Our Ref: TR020001

Date: 16 May 2023

Application by London Luton Airport Limited for an Order Granting Development Consent for the London Luton Airport Expansion project

Procedural Decision made under Section 89(3)

Figure 9.1: Community First zone

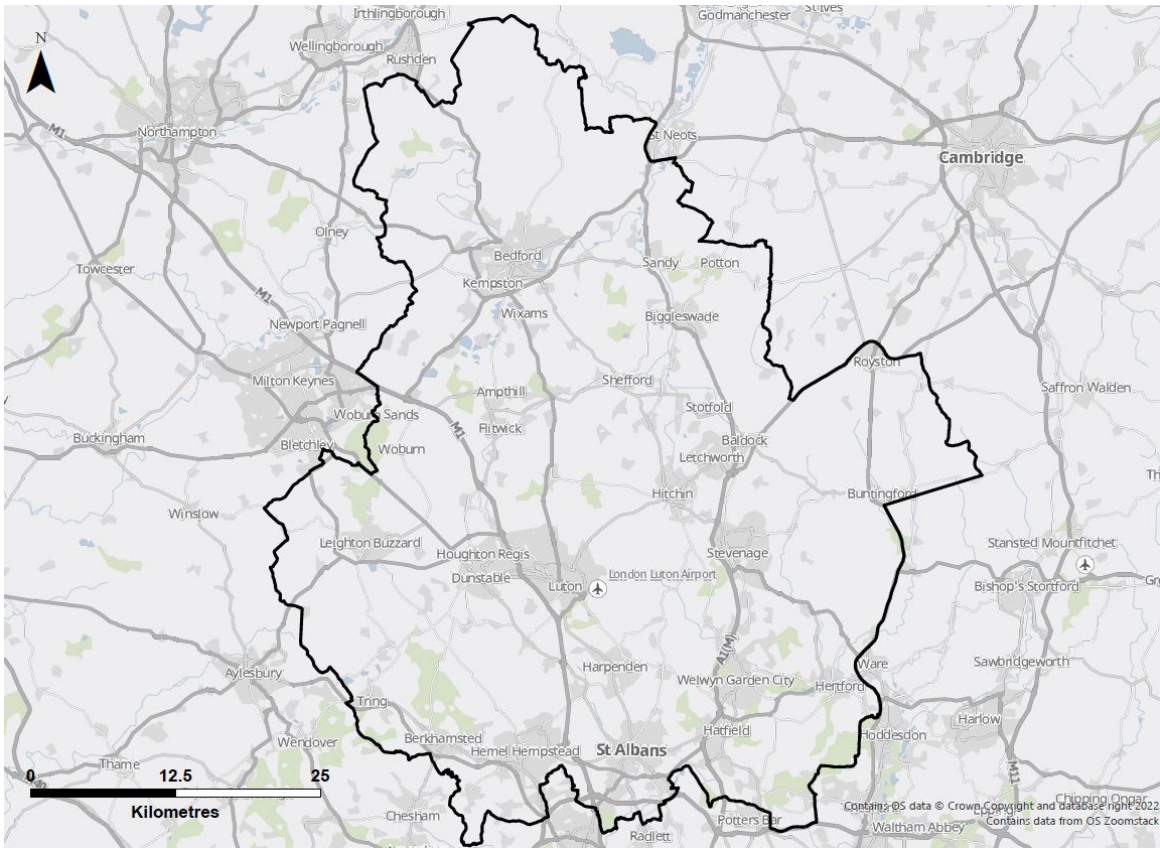
AS-007	Explanatory Memorandum	Paragraph 4.25 reads in the second sentence – ‘...an exceedance of an air quality it is considered...’. Confirm whether this should read air quality ‘threshold or limit’ it is considered....
AS-007	Explanatory Memorandum	Paragraph 4.38 typographical error – ‘and a processes to vary’.
AS-008	Statement of Reasons	Paragraph numbering restarts/repeats after paragraph 12.1.7.
AS-010	Scheme Layout Plans	Assessment Phase 2a – Two stockpile areas proposed to west of Winch Hill Road annotated as ‘F’ instead of ‘G’.
AS-050	Draft Compensation Policies, Measures and Community First	New Figure 9.2 (Community First Zone) should be Figure 9.1. PDF title is ‘Compensation Policies and Measures Final at 12 Jan’, given

Figure A1.1: Indicative noise contour plan

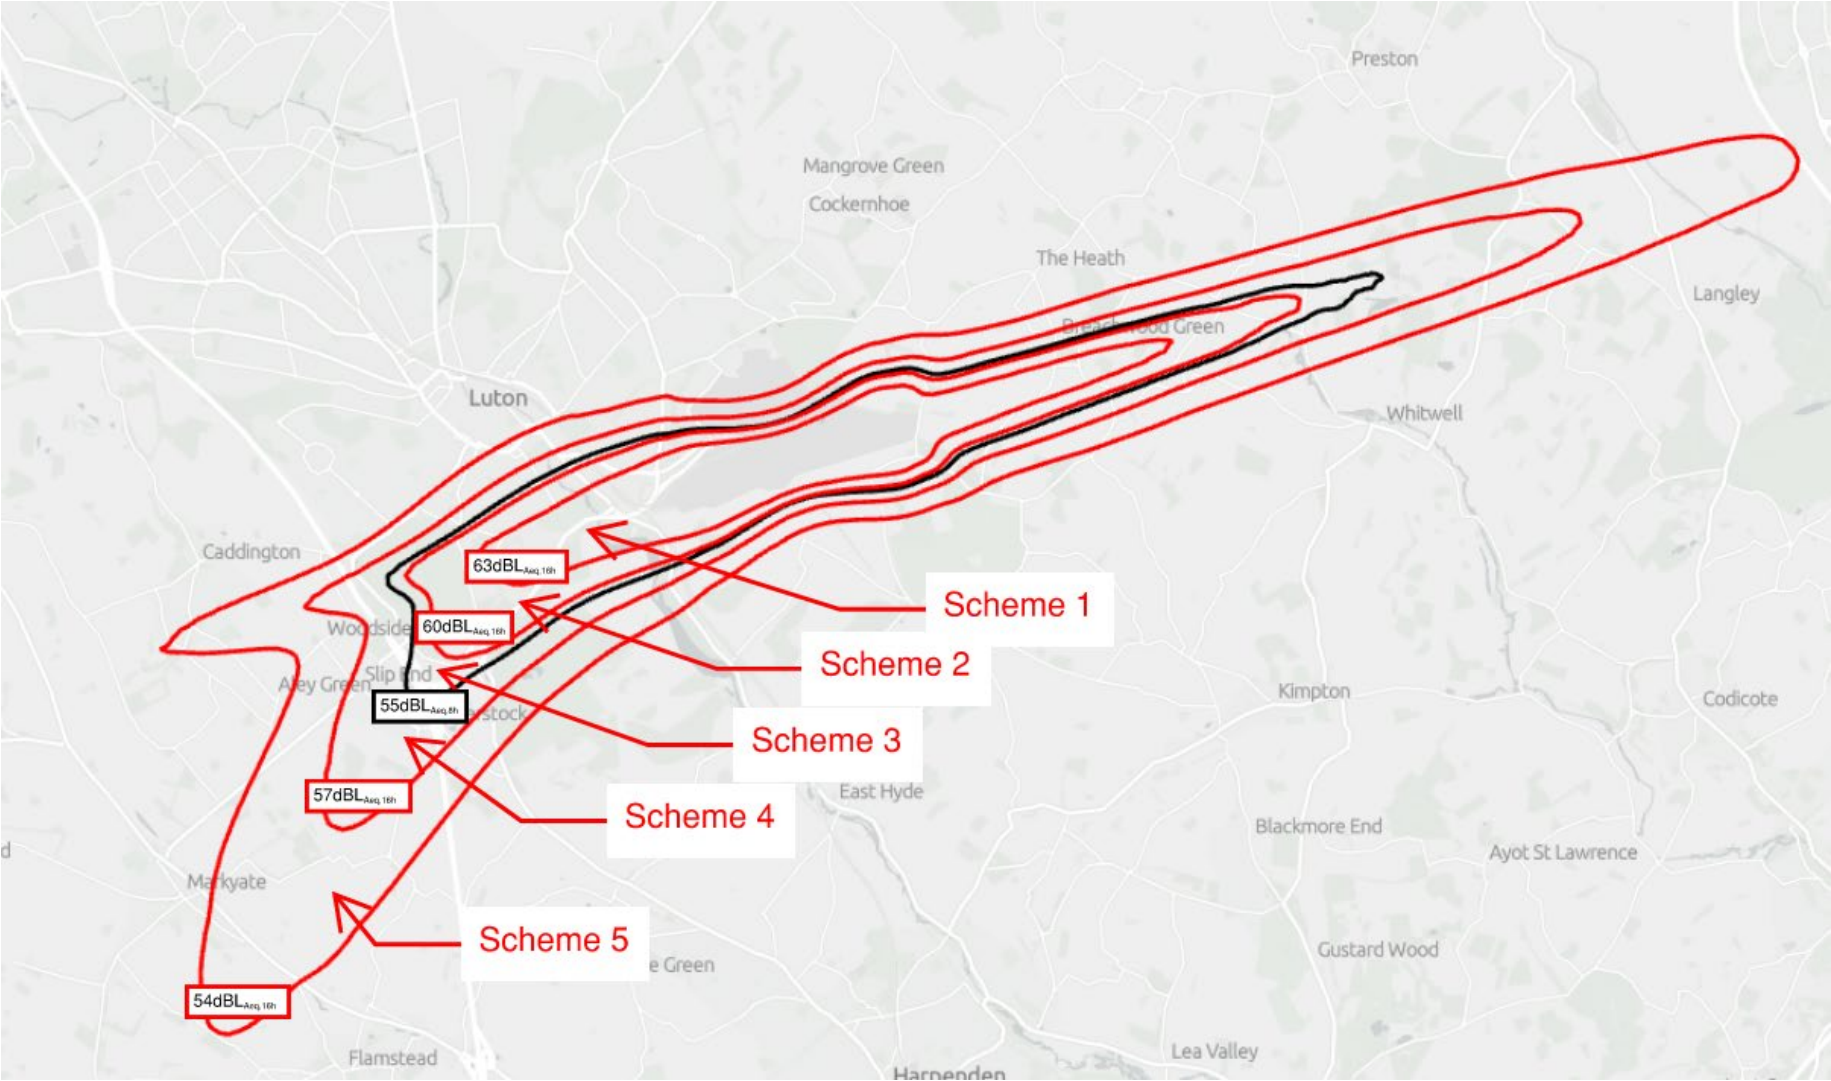
that the Issue 1 was dated February 2023 this title seems at odds with the revision history. Retitle.
AS-050	Draft Compensation Policies, Measures and Community First	Appendix A contains an Indicative Noise Contour plan. Provide a copy of the plan at A3 with a 1:50,000 Ordnance Survey Landranger background for each assessment phase and provide a second set of plans with the current eligibility contours overlaid on the new contours in a different colour.
